City of Albuquerque SWPPP Inspection Checklist

Project Name:	Caliber Collision	Project Operator:	Cross Development
Project Location:	1	Contact Name:	Russell Vaughn
NPDES Permit Number:		Contact Number:	
Date of Inspection:	9/19	Contact Email:

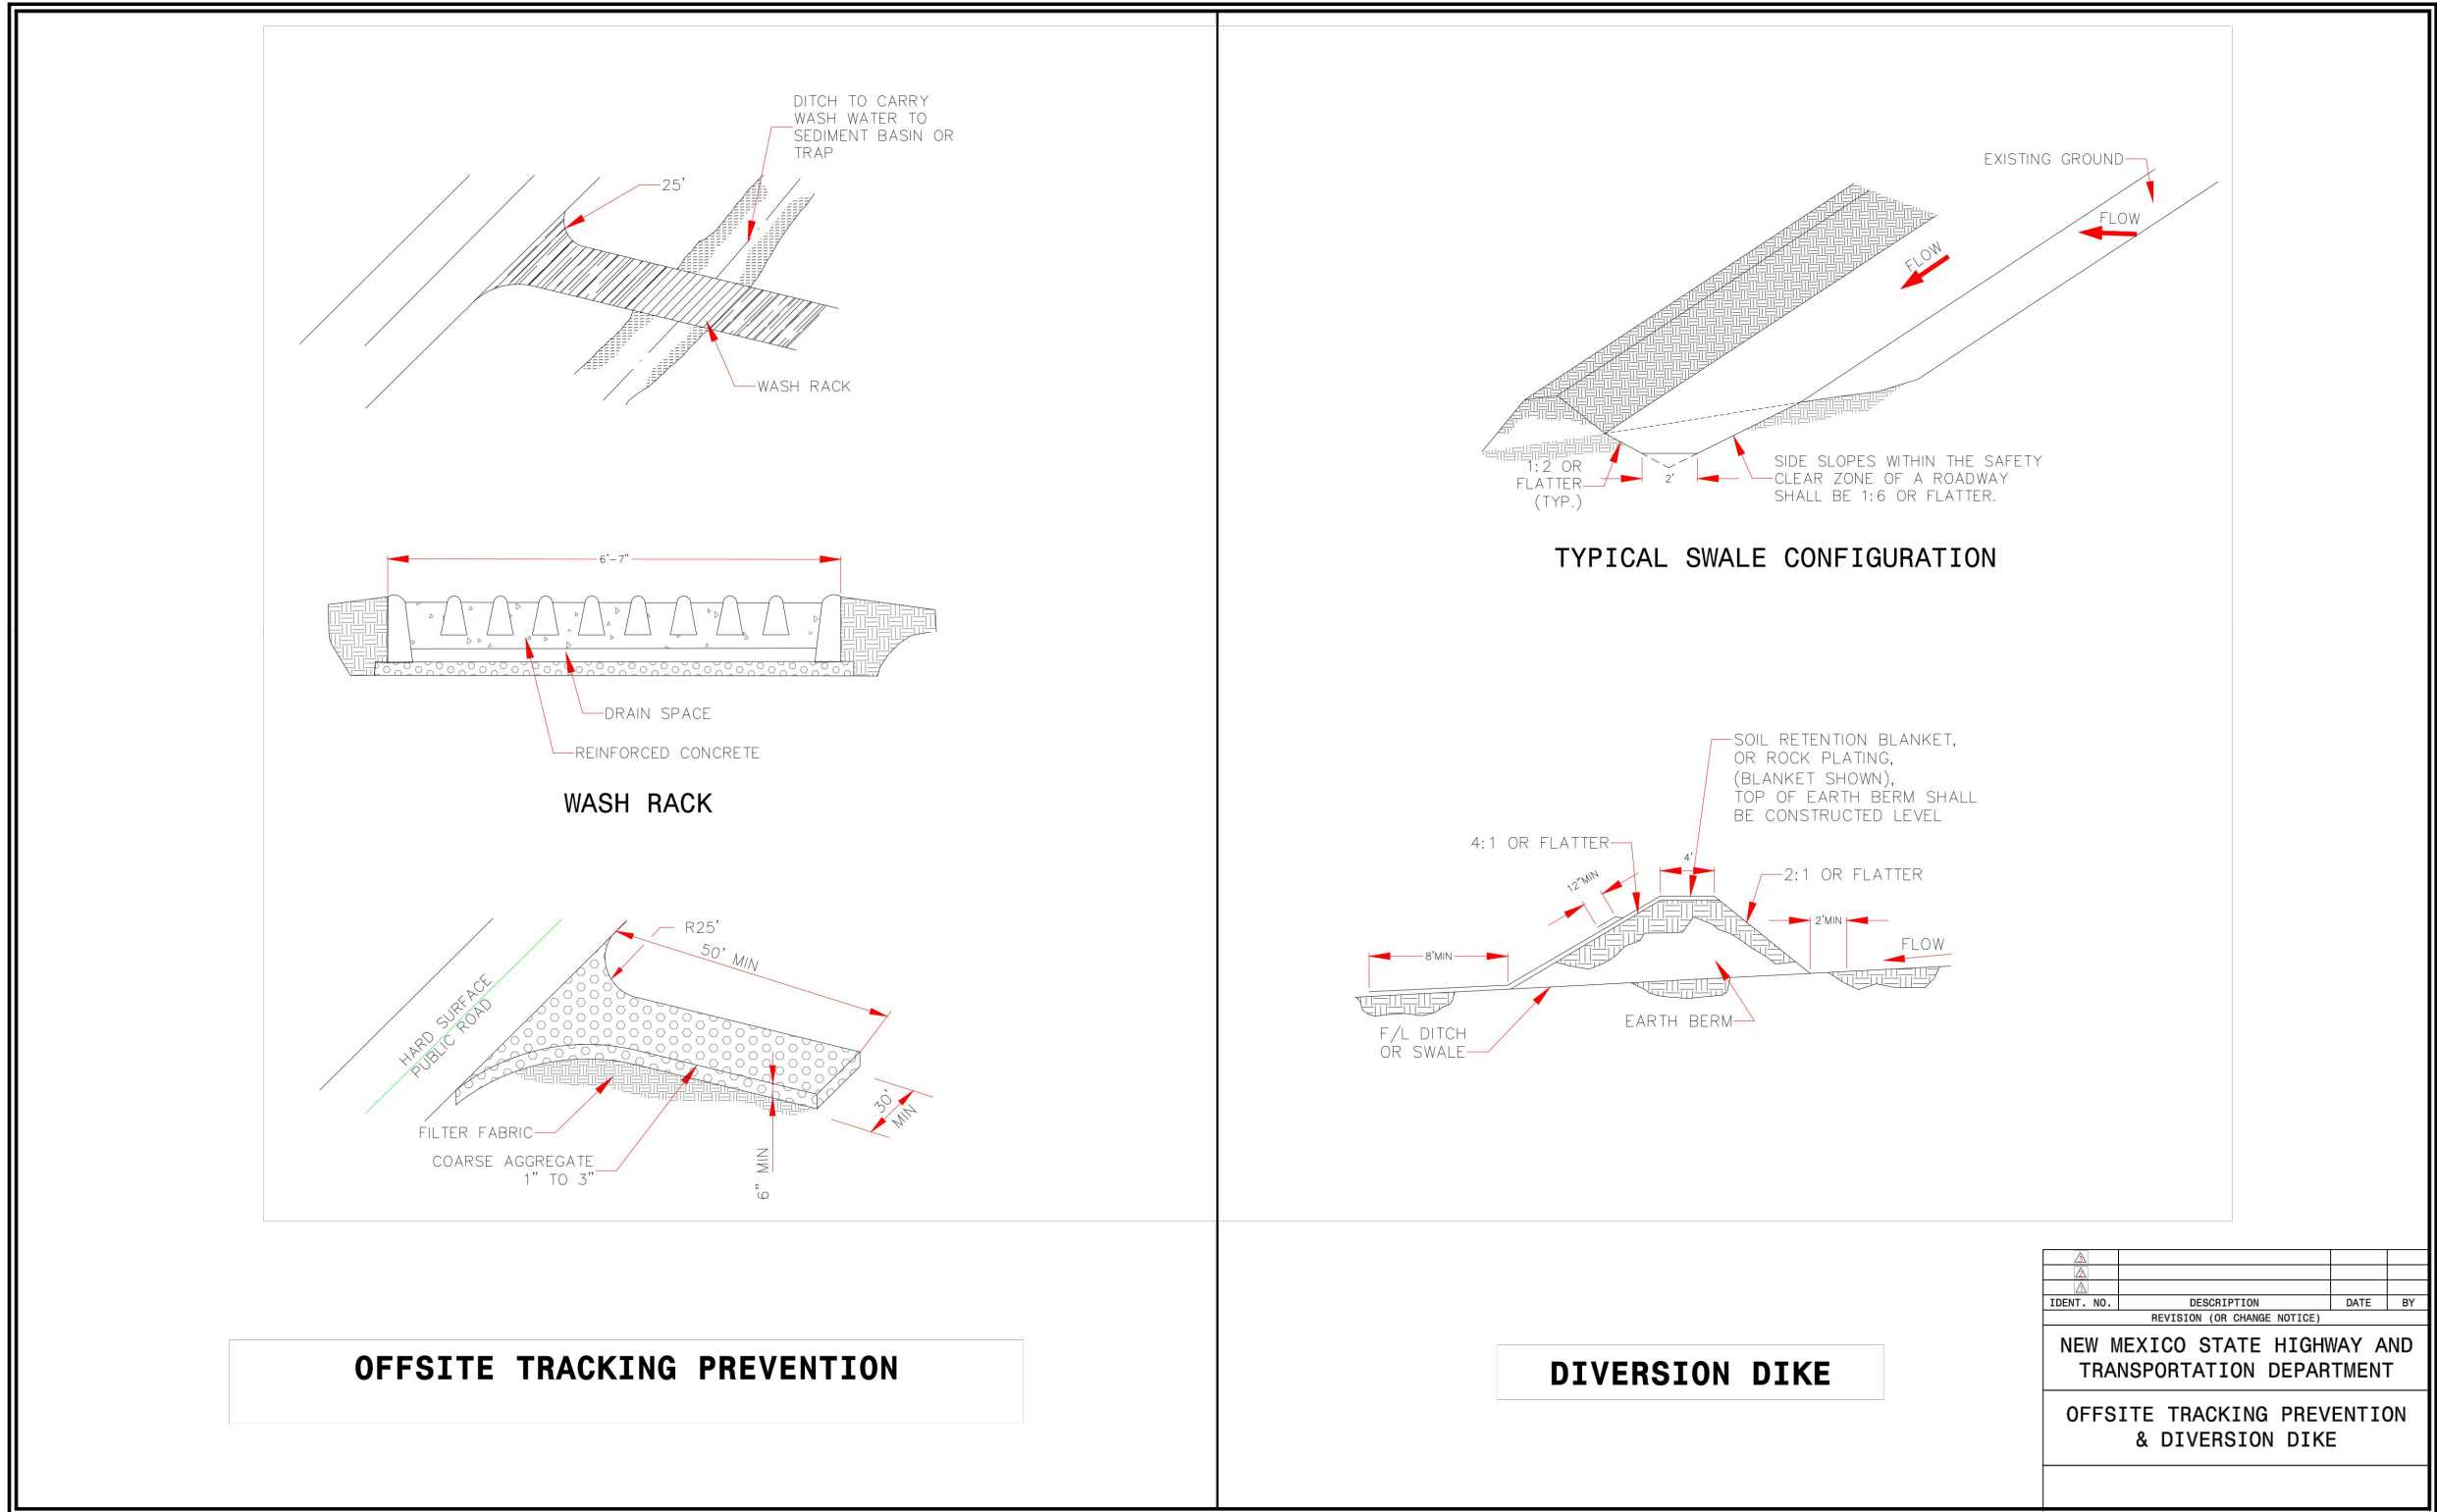
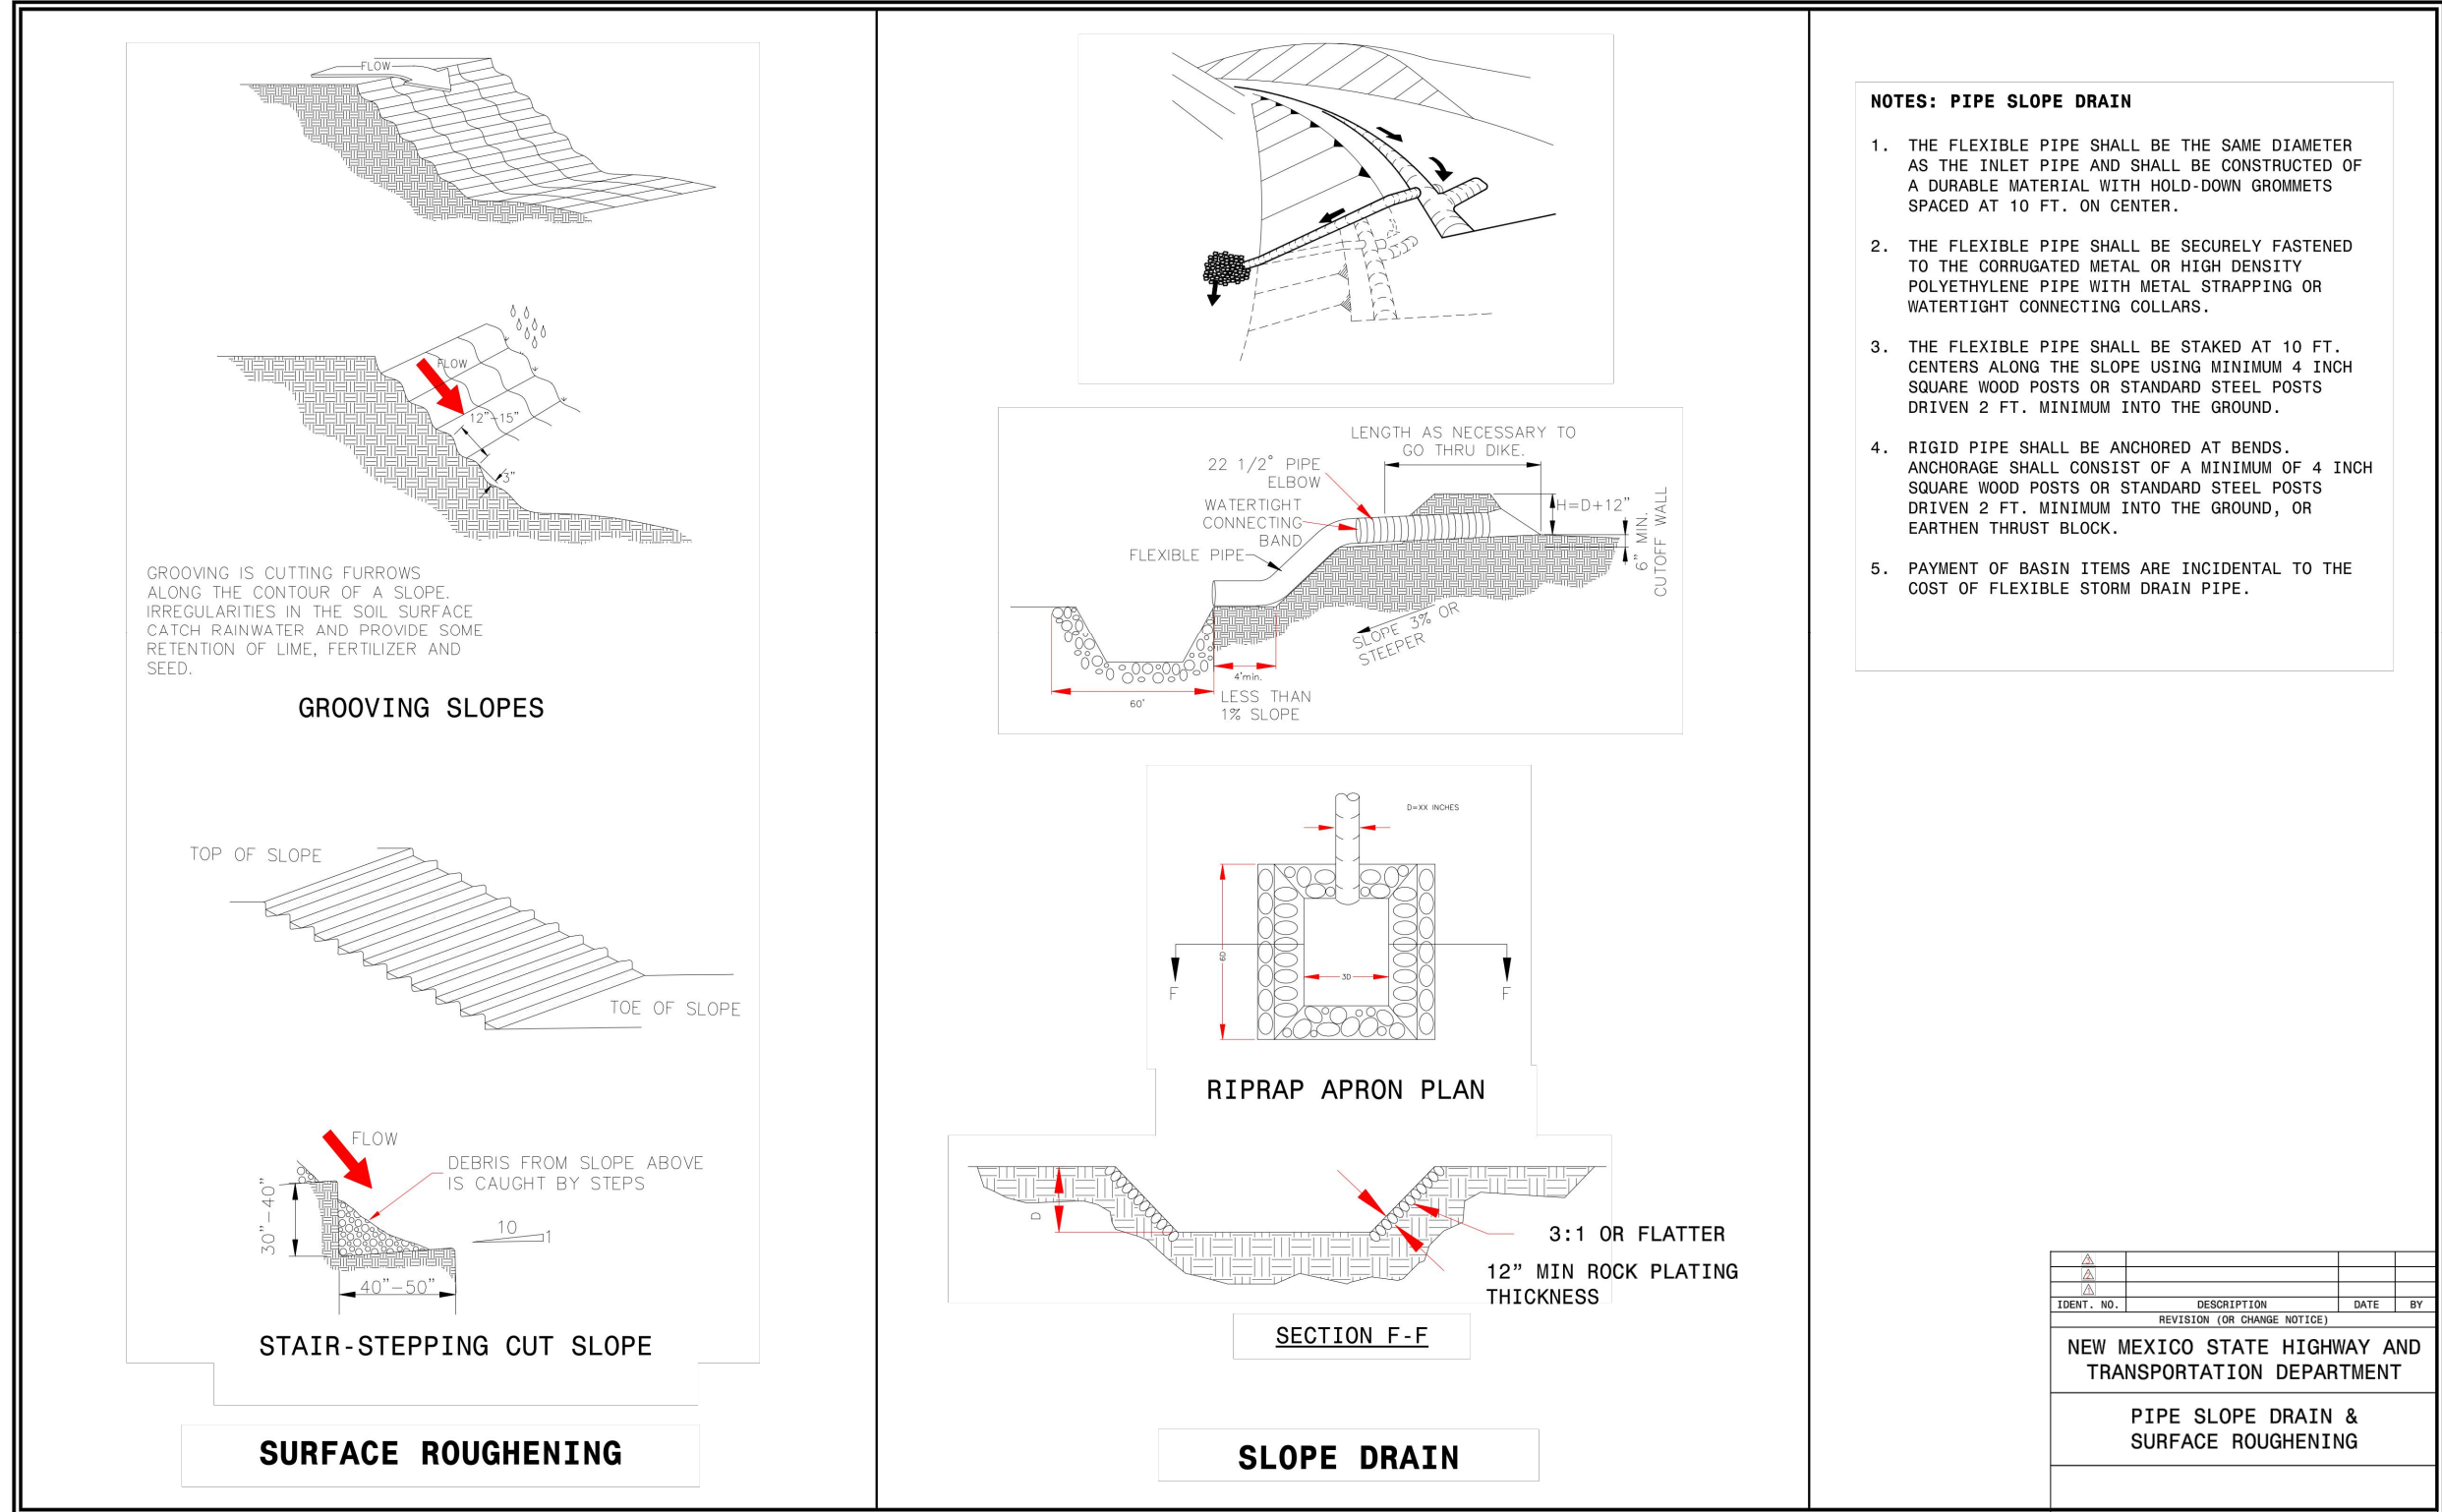
South Silt Fence Missing
